**From:** Anita Gardner <Anita.Gardner@arun.gov.uk>  
**Sent:** 07 January 2021 14:28  
**To:** Planning.Responses <Planning.Responses@arun.gov.uk>  
**Subject:** FW: M/75/20/PL - 13 Elm Drive

I have checked to see whether the forward shifting of the proposed dwelling will require re-advertising and I can advise that it won't. As discussed I await receipt of the preliminary FRA and the revised plans. Can you also advise of the gross internal floor area of the dwelling?

**Subject:** M/75/20/PL - 13 Elm Drive

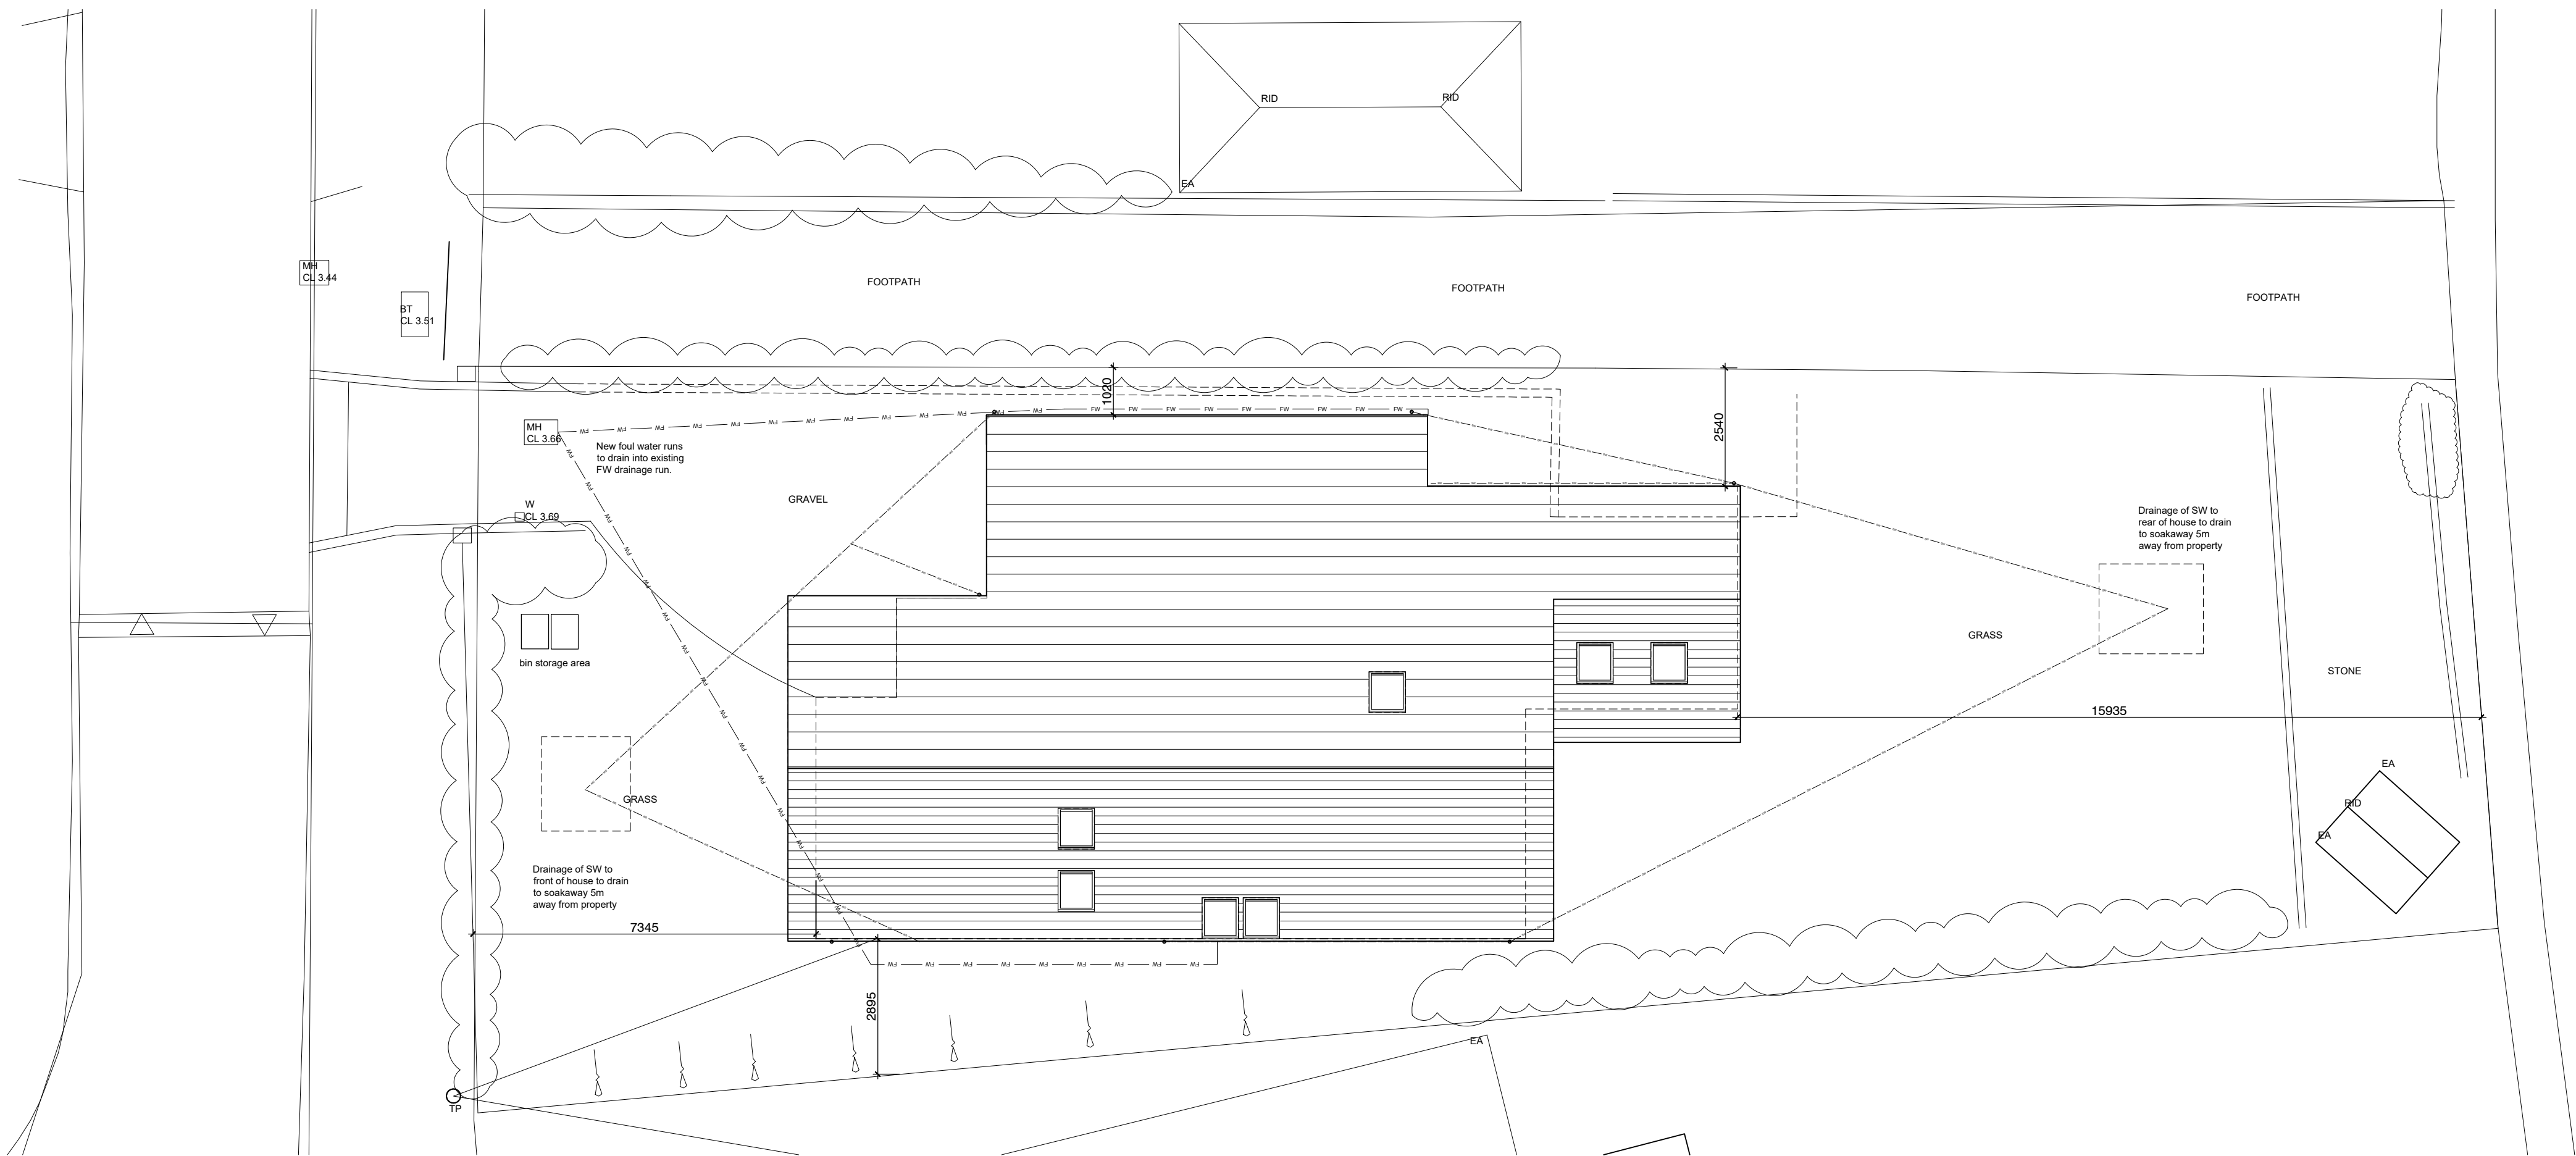
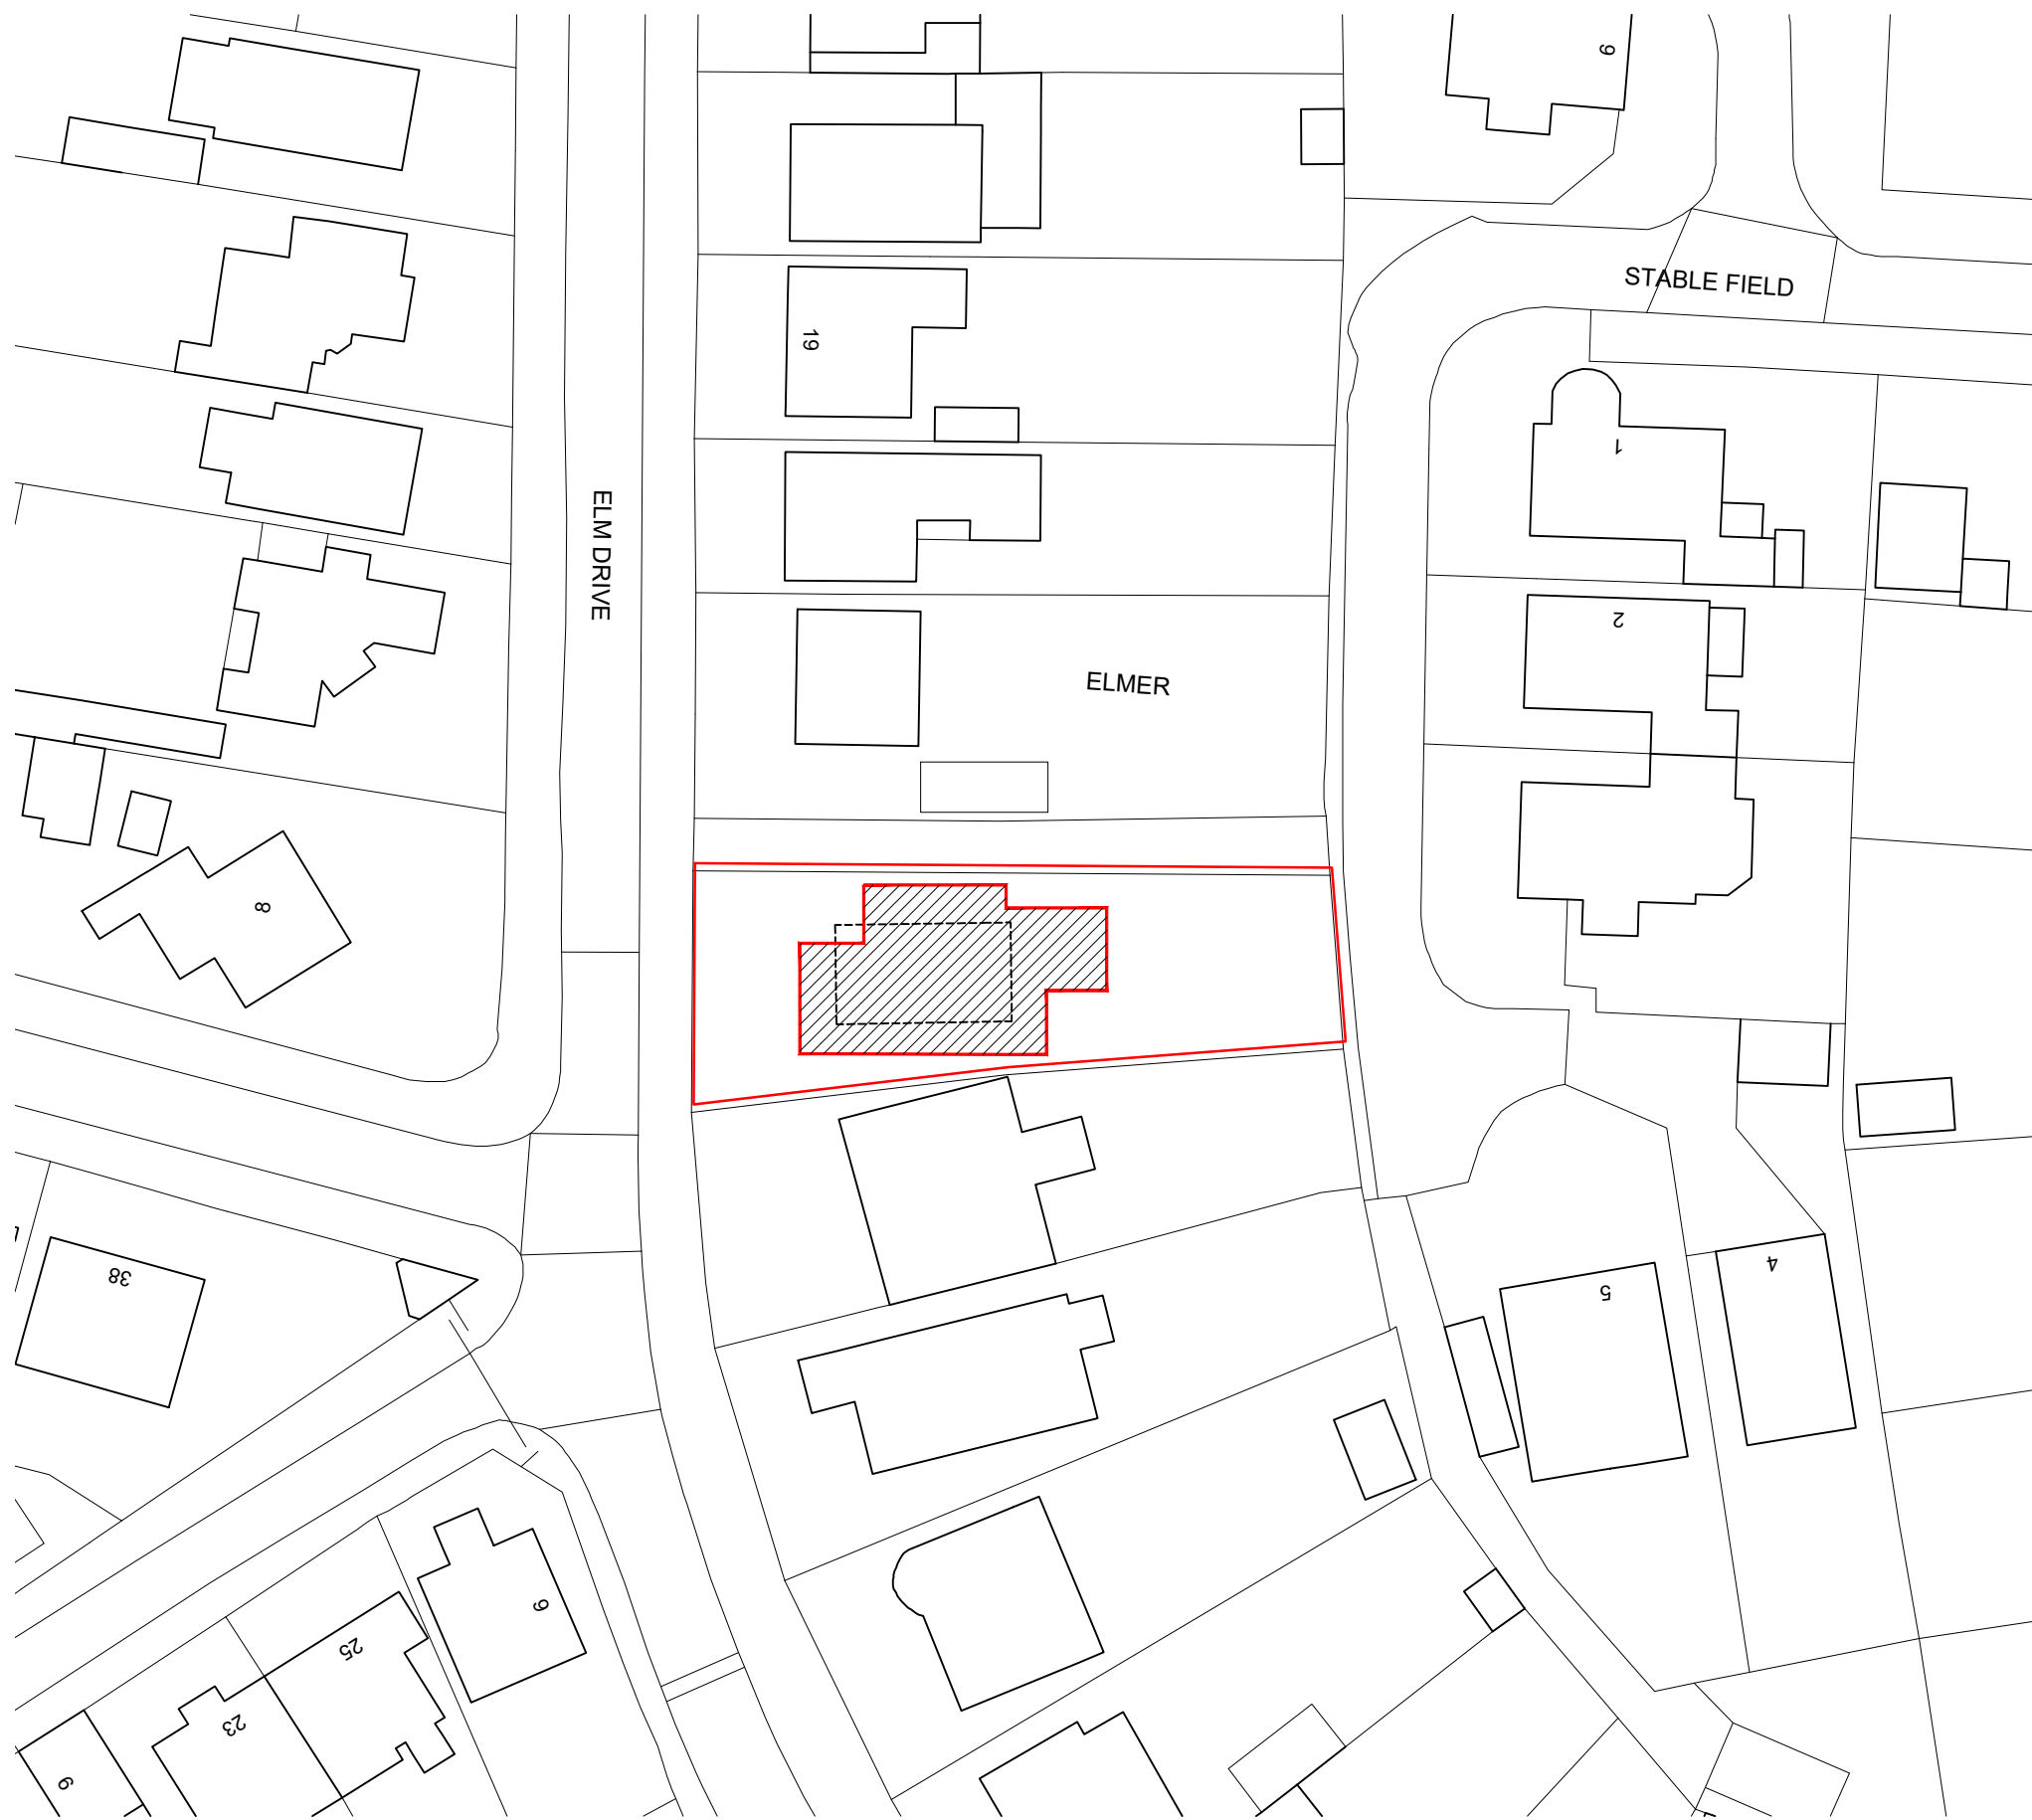
I have had the opportunity to look at your submitted application whilst awaiting the submission of the FRA and I am concerned about the height of the proposed dwelling in relation to the southern boundary. The proposal represents a significant increase in height and site coverage which is not an issue in principle, but it results in an adverse impact in the south eastern 2 storey corner of the proposal. This is too close to the adjacent dwelling no 11 and given the orientation of both dwellings would not accord with the 45 degree rule and would be overbearing to the dwelling and garden area and adversely impact the outlook from the neighbouring property.

If the FRA is on track for submission tomorrow I would suggest that you consider amending the proposal by reducing the development in the south east corner to provide a better relationship with the adjoining dwelling so that these changes can be provided whilst the Environment Agency are consulted. If the FRA is not likely to be ready by the end of this week I would suggest that the application is withdrawn and re-submitted in the new year with amended plans reducing the footprint and an FRA.

Thanks for your email. That is good news! Please find attached revised drawing 2.01A and 2.02A and the Flood risk assessment (subject to receiving the EA data). The gross internal floor area of the proposed dwelling is 245m2.

Further to your email we have look at the position of the proposed dwelling in relation to no.11 Elm drive. Please find attached a revised site plan which shows the proposed dwelling brought forward in order to sit outside the 45 degree line shown on the drawing. Please can you let me know if this would be acceptable? Please note the revised position still sits withing the existing building line along the street.
